Application No: FG/184/21/PL
Site Address: 1 Greenways Crescent Ferring BN12 5EF
Description of works: Erection of replacement dwelling and garage

Thank you for your internet representation made on 3rd December 2021 which has been recorded as an objection with the comments as follows:

Figure 2: Existing and proposed east elevations

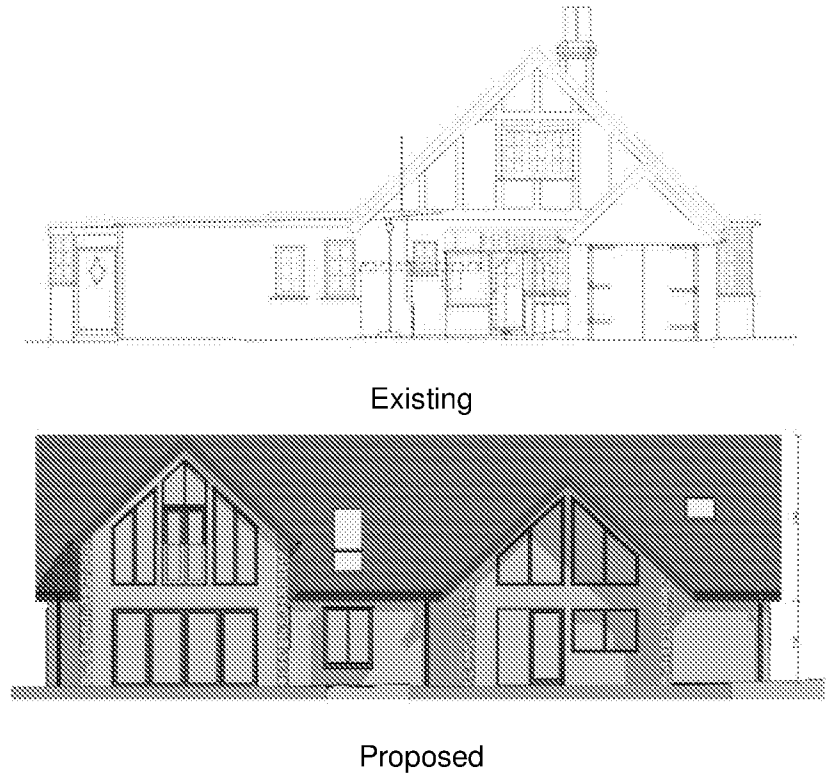
The proposals are in direct contrast to this with the highest point being considerably closer to the road than the existing building with eaves overhanging even further than the proposed northern elevation further compounding the overbearing effect.

Viewed from the east and west the proposals will create a large mass that juts out in to the very centre of the cul-de-sac and as such is out keeping with the other properties numbered 2-9. It will be dominant and overbearing on the street-scene due to it being forward of the existing building line and the change in orientation of the roof slope. It will have more of an adverse affect on numbers 7&8 due to moving the building forward of the building line and will reduce the privacy that they currently have in their main bedrooms from the large section of glazing on the north elevation.

Figure 7: Proposed garage

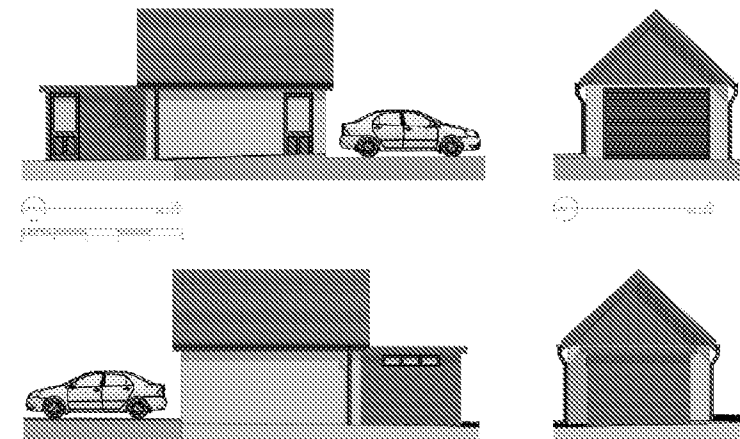
The garage to the rear of the property is unnecessarily high and overbearing in relation to Number 2 due to its proximity to the boundary.
